Our Ref: AL/7/19/HH
Your Ref:

Town & Country Planning Act 1990 (as amended)
Town & country Planning (Development Management Procedure) (England) Order 2015
Application for Planning Permission for Works or Extension to a Dwelling

Development Demolition of existing conservatory & replacement roof to provide additional accommodation.
Location Kittenash Hook Lane Aldingbourne

SITE LOCATION PLAN
AREA 2 HA
SCALE 1:1250 on A4
CENTRE COORDINATES: 493498, 104748

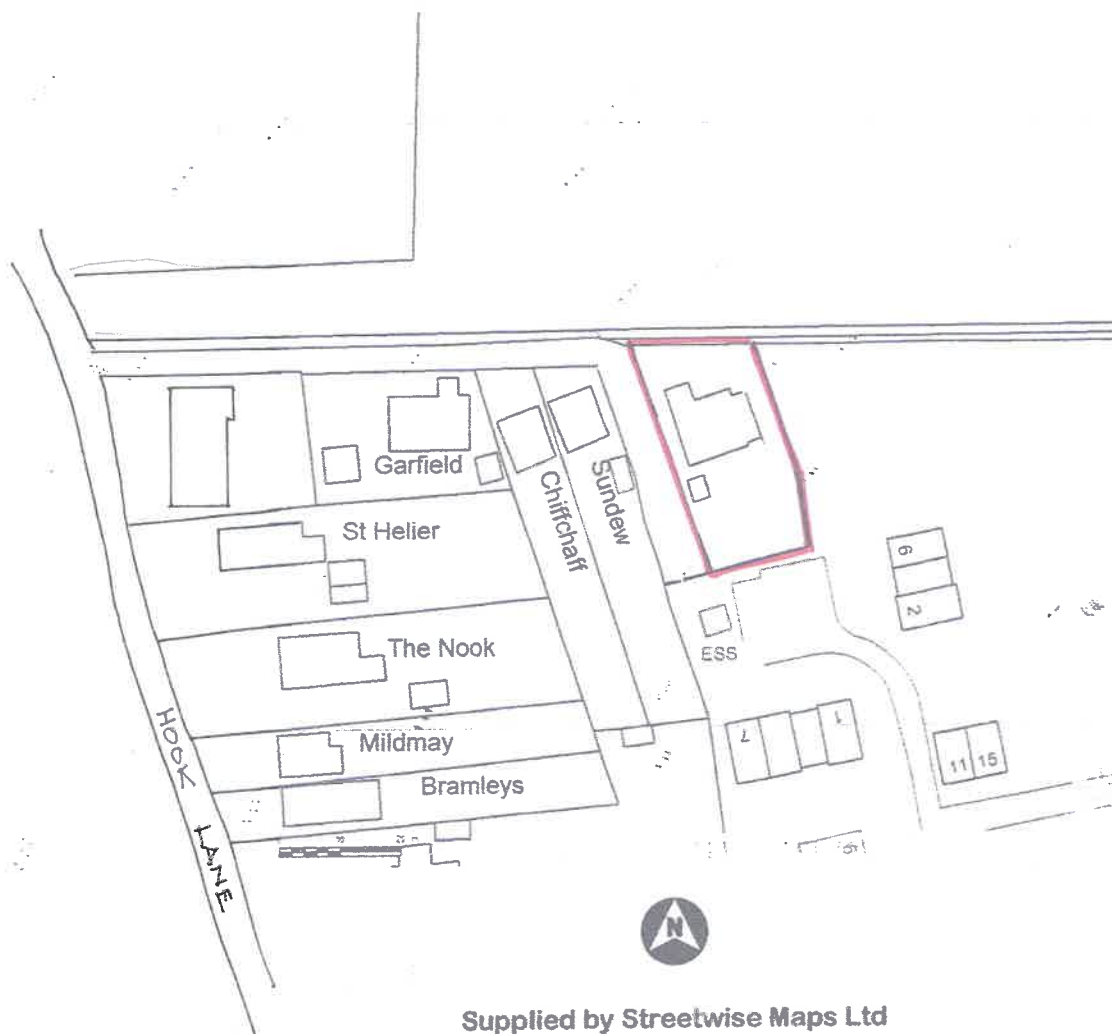
Location Plan Amend

Please provide two named roads.
